M42 Junction 6 Development Consent Order Scheme Number TR010027

8.98 Applicant's Comments on any Additional Information or Submissions Received by Deadline 8

**Applicant's Comments on any Additional Information or Submissions
Received by Deadline 8**

Version	Date	Status of Version
1	15 November 2019	Final for submission at Deadline 9

Figure 7.1: DM 2021 and 2041 peak hour flows

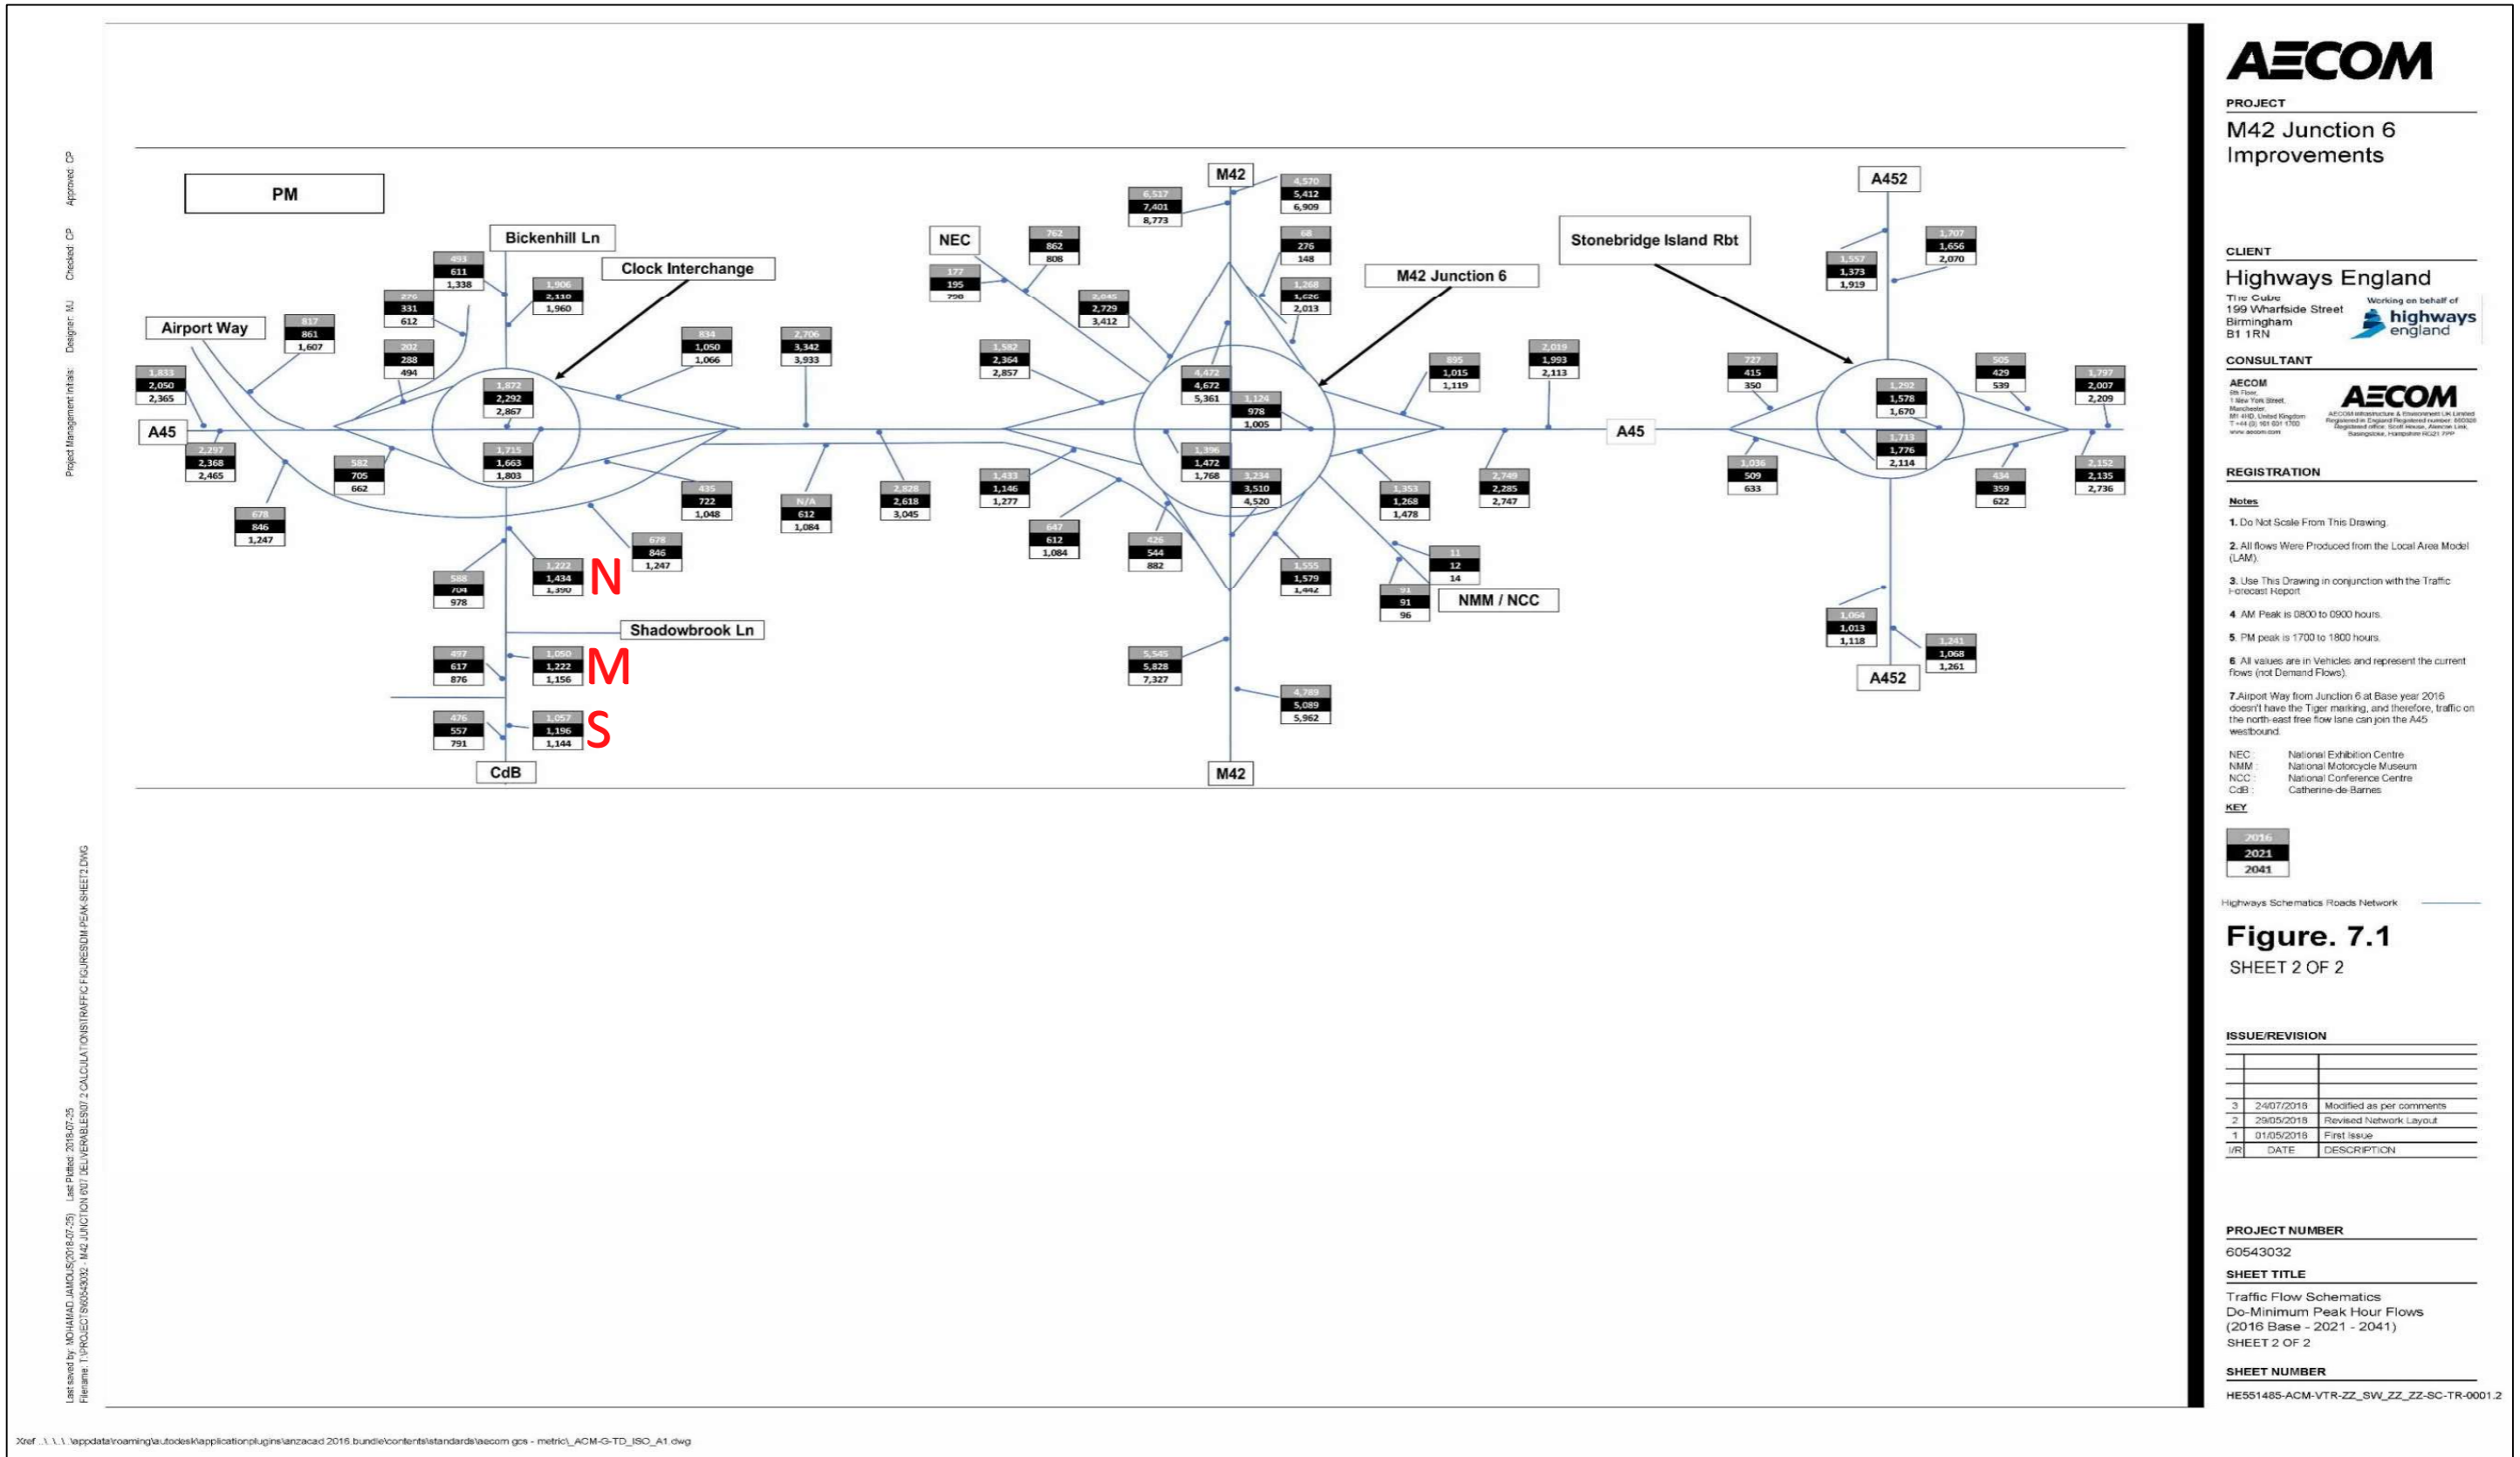
Submitted by	Title	Comments																																																												
		<p>ISSUES WITH THE FORECAST TRAFFIC FLOW DIAGRAMS FOR CATHERINE DE BARNES LANE (See Appendix C):</p> <p>The forecast Traffic Flows are shown in the following diagrams:</p> <p><i>Figure 7.1 - the 'DM' (without the improvement scheme) forecast Traffic Flows for the AM, IP and PM peak hours in the 2016 base year and the 2021 and 2041 future years.</i></p> <p><i>Figure 7.2 - the 'DS' (with the improvement scheme) forecast Traffic Flows for the AM, IP and PM peak hours in the 2021 and 2041 future years.</i></p> <p><i>Figure 7.3 - the 'DM' (without the improvement scheme) forecast AADT flows in the 2016 base year and the 2021 and 2041 future years.</i></p> <p><i>Figure 7.4 - the 'DS' (with the improvement scheme) forecast AADT flows in the 2016 base year and the 2021 and 2041 future years.</i></p> <p><i>Figure 7.5 - the differences between the 'DS' and 'DM' forecast Traffic Flows for the AM, IP and PM peak hours in the 2021 and 2041 future years.</i></p> <p><i>Figure 7.6 - the differences between the 'DS' and 'DM' forecast Traffic Flows in terms of AADT flows in the 2021 and 2041 future years.</i></p> <p>Figure 7.1 - Do-Minimum Peak Hour Flows (2016 Base – 2021 – 2041)</p>

<ul style="list-style-type: none"> - All other roads on the diagram show an increase in Traffic Flow in year 2041 but Highways England are stating that Southbound Traffic Flow on Catherine de Barnes Lane will be lower during AM and PM hours, and higher during IP hours, in 2041 when compared to 2021 - Almost half the Traffic Flow in AM hours is going missing on the journey from the north end of Catherine de Barnes Lane to the south end - There appears to be a false assumption that a lot of traffic is / will be using Shadowbrook Lane 	Southbound AM Data taken from Figure 7.1				Southbound IP Data taken from Figure 7.1				Southbound PM Data taken from Figure 7.1				Year	North End	Middle	South End	Year	North End	Middle	South End	Year	North End	Middle	South End	2016	614	409	360	2016	347	285	262	2016	1222	1050	1057	2021	634	419	366	2021	461	359	329	2021	1434	1222	1196	2041	514	310	272	2041	631	485	435	2041	1390	1156	1144
Southbound AM Data taken from Figure 7.1				Southbound IP Data taken from Figure 7.1				Southbound PM Data taken from Figure 7.1																																																						
Year	North End	Middle	South End	Year	North End	Middle	South End	Year	North End	Middle	South End																																																			
2016	614	409	360	2016	347	285	262	2016	1222	1050	1057																																																			
2021	634	419	366	2021	461	359	329	2021	1434	1222	1196																																																			
2041	514	310	272	2041	631	485	435	2041	1390	1156	1144

Submitted by	Title	Comments
		<p>- In 2041, 12953 more vehicles will exit Clock Interchange traveling south and 11275 of these vehicles will continue onto the Mainline Link road. It appears there will be an increase of 1678 vehicles using the Realigned Catherine de Barnes Lane in 2041</p> <p>Given the above it is difficult to conclude that Highways England are correct when stating the annual average daily Traffic Flow southbound to Catherine-de-Barnes Lane shall be 8,532 under the do minimum scenario compared to 8,348 under the do something scenario.</p> <p>In fact, it is glaringly obvious that they have simply cherry-picked data in an attempt to justify their argument.</p> <p>It also appears that their Traffic Flow data is seriously flawed.</p> <p>As HE have used this flawed Traffic Flow data in their air quality assessment document 'TR010027-000139-TR010027_M42J6_6-1_Environmental_Statement_Chapter_6' and noise assessment document 'TR010027-000145-TR010027_M42J6_6-1_Environmental_Statement_Chapter_12' one must assume that these documents are not a true reflection of the impact of the scheme and they must be updated accordingly before any decision is made by the ExA.</p> <p>The Applicant comment:</p> <p>The Applicant's response to Action point 20 within Volume 8.86 [REP7-011/Volume 8.86] referred to southbound traffic along Catherine-de-Barnes Lane where it reaches Catherine-de-Barnes roundabout, not where it will reach the new Barber's Coppice roundabout. This is because the Applicant is of the view that this is the area currently most susceptible to the congestion described by Mr O'Reilly.</p> <p>Mr O'Reilly's subsequent comments largely relate to the traffic flow numbers not 'adding up' between road sections within the Transport Assessment Report (TAR) [APP-174/Volume 7.2]. The comments also question the validity of the traffic flow data which has been used to inform the air quality and noise assessments.</p> <p>The Applicant can confirm that the traffic flows presented in Figures 7.1 to 7.6 of the TAR provide a summary of the forecast flows produced by the M42 Junction 6 Local Area Model (LAM). As the figures referred to by Mr O'Reilly are summary figures, these do not provide flow information for</p>

Submitted by	Title		Comments
			<p>every road section which is why the totals do not add up and are not meant to. The Applicant's selection of links was made to simplify the presentation of the flows while allowing some comparisons to be made between forecast years and scenarios. The full information is contained in the LAM and informed both the traffic and environmental assessment, including the assessments of air quality and noise.</p>
Philip O'Reilly	Response to action points: ISH 7 on the draft Development Consent Order – 23 rd October 2019	16	<p>Philip O'Reilly comment:</p> <p>I can confirm a letter from Chris Harris (Highways England) was attached to an email received from Lydia Barnstable (AECOM) on 25th October 2019 and marked 'Private and Confidential'. However, it does not address the concerns I have raised. In short:</p> <ul style="list-style-type: none"> - The letter advises that I should engage a professional advisor but does not confirm that Highways England will meet the cost. - The letter confirms that works will be undertaken but does not provide any information or plan showing the extent of those works. - It is disappointing to say the least that Highways England are still unable to confirm how my property is affected by their scheme. - The letter does not confirm how the main access and the rear access to my property will be treated. - Instead of agreeing any fencing or boundary treatment to my property directly with Highways England it will need to be agreed with the Principal Contractor. - Although the works in front of my property have not changed a great deal since January 2018 Highways England have still not completed the Land Registry checks (but advise that they will be completed by 2nd November 2019) and therefore cannot confirm what land will revert to my ownership under the ad medium filum rule. No information has been provided prior to Deadline 8. - I would prefer to have control, and therefore ownership, of as much of the land outside the current boundary to my property up to the realigned Catherine de Barnes Lane to ensure it is properly maintained.
